SF2014/036013
CR2015/005907
DC

GOLDEN HIGHWAY (B84): DOLWENDEE QUARRY PROJECT, LOT: 2 DP: 1160936, 770
MERRIWA ROAD, DOLWENDEE (SSD 6519)

Roads and Maritime has reviewed the information provided including the Traffic Report by Colston Budd Hunt & Kafes dated November 2012, and proposed haul road plans by RHM Consulting Engineers dated August 2015. Roads and Maritime has no objections to the subject project provided the following requirements are included in the Minister's conditions of project approval:

Figure 7: Layout of haul road from quarry

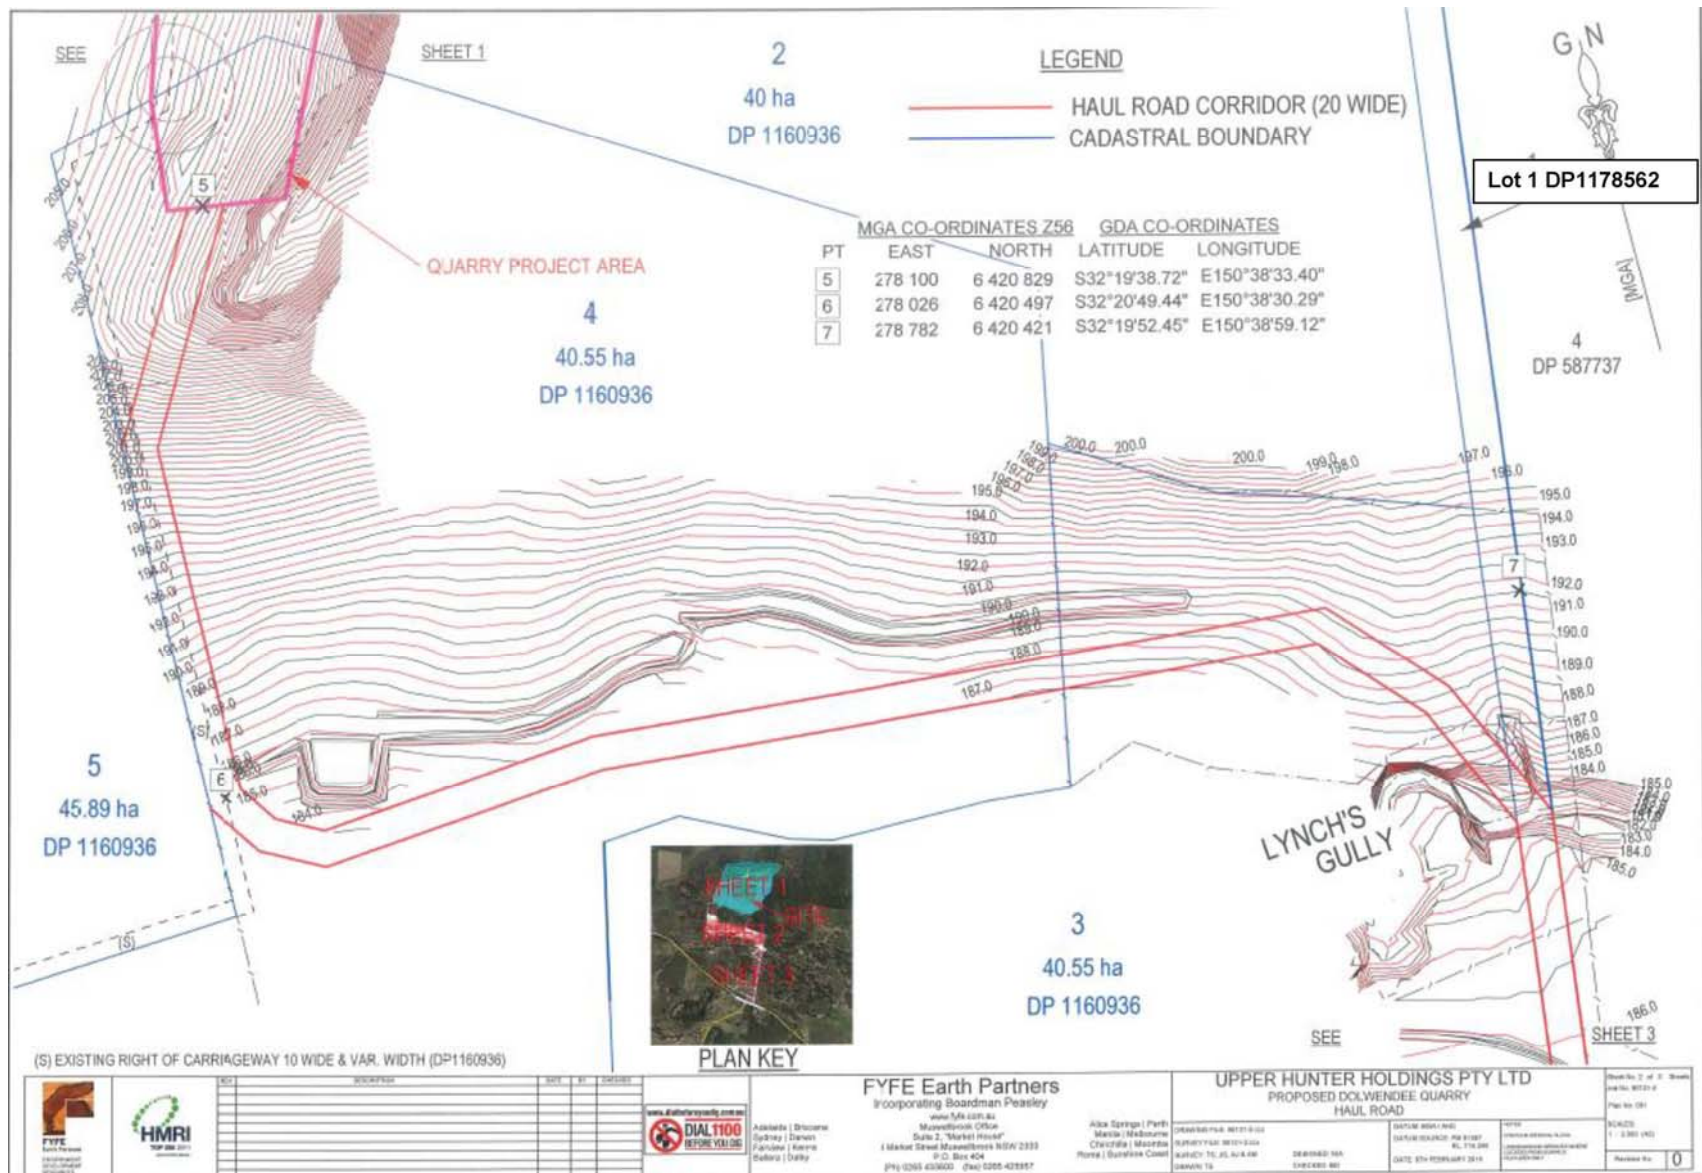
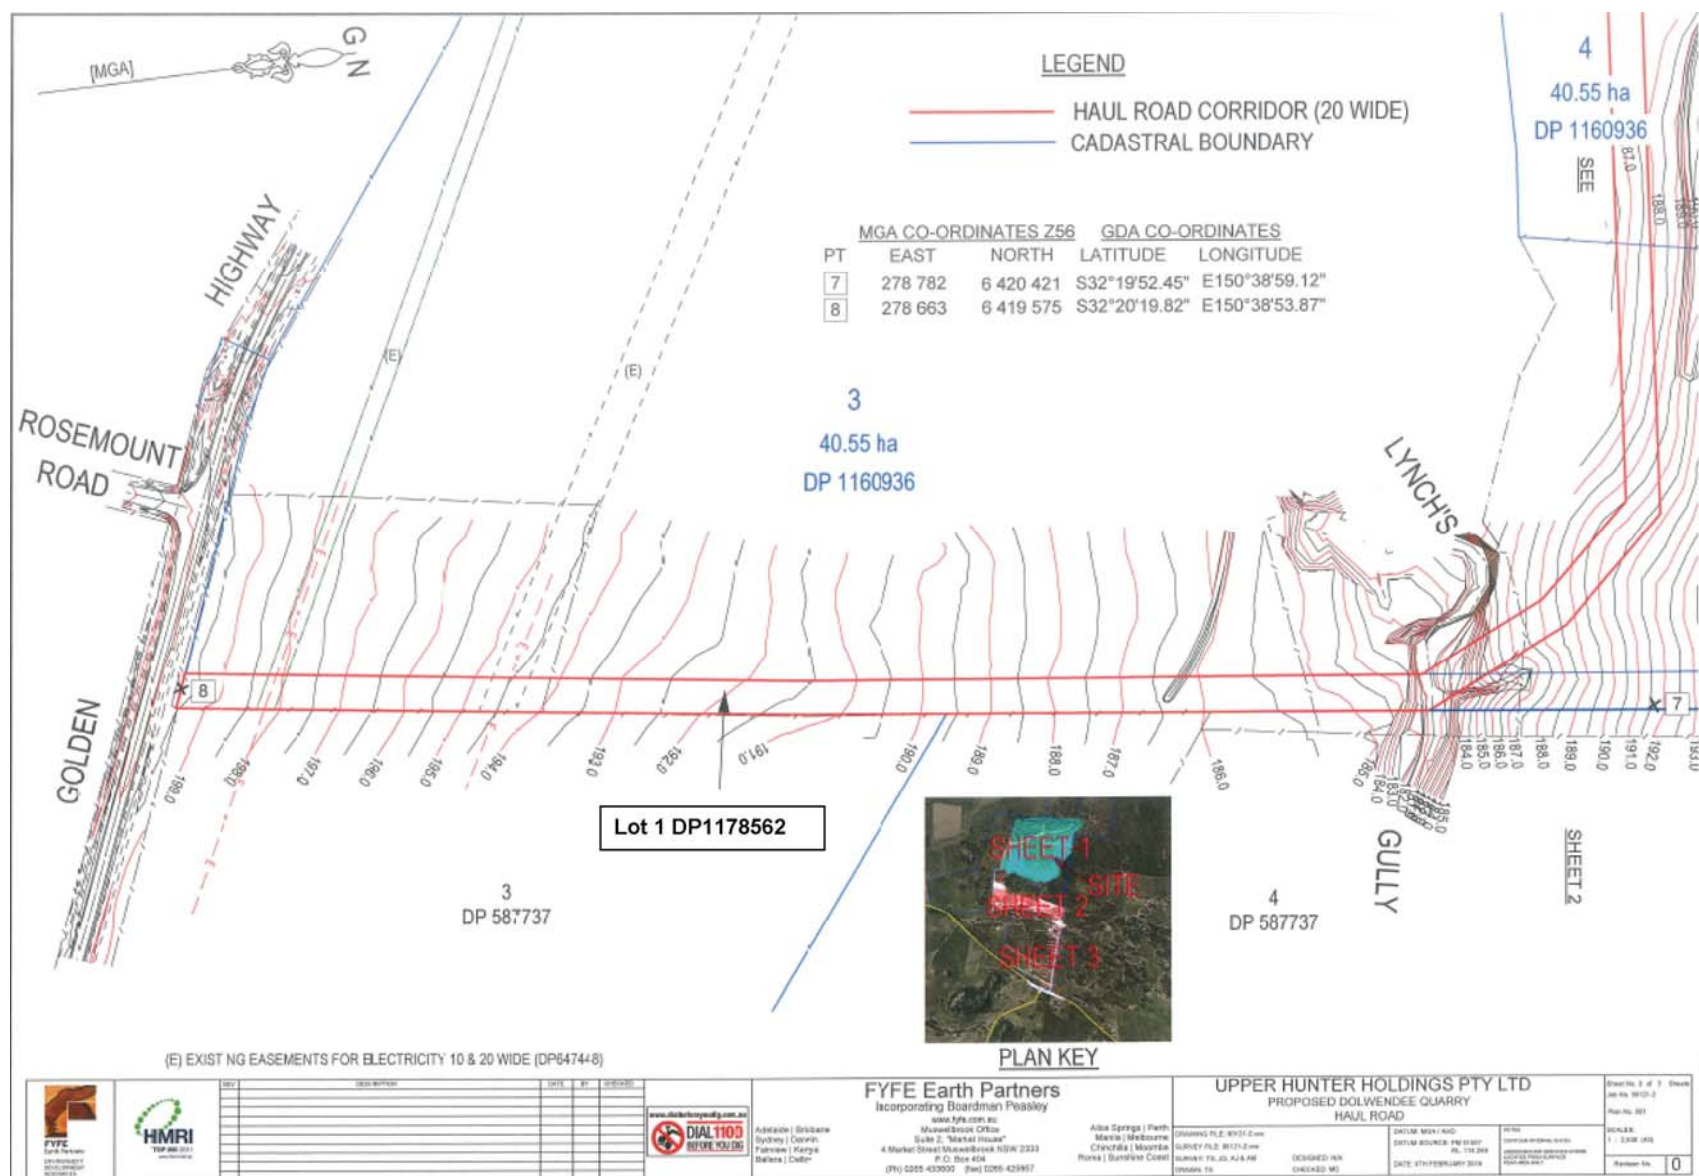
- Prior to the commencement of construction activities and the mining operation associated with the proposed project, the new intersection with the Golden Highway shall be upgraded to a BAR / AUL type intersection. The intersection shall be designed and constructed in accordance with Austroads *Guide to Road Design 2010* (with Roads and Maritime supplements) and all other relevant guides, policies and standards, to the satisfaction of Roads and Maritime and Council. The following requirements will apply to the intersection:
 - The haulage road shall be aligned to intersect the Golden Highway at 90 degrees.

- The intersection shall be designed to accommodate the turning path of the largest design vehicle.
- Adequate sight distance shall be provided for vehicles entering and exiting the site.
- Advanced intersection warning and all other road signs shall be provided on the Golden Highway, as determined by Roads and Maritime.

- The new haul road shall be constructed to cater for heavy vehicles and suitably paved for a minimum of 50m from the intersection of Golden Highway.
- Stormwater from the haulage road shall be adequately catered for within the site and shall not exceed the capacity of the Golden Highway stormwater drainage system.
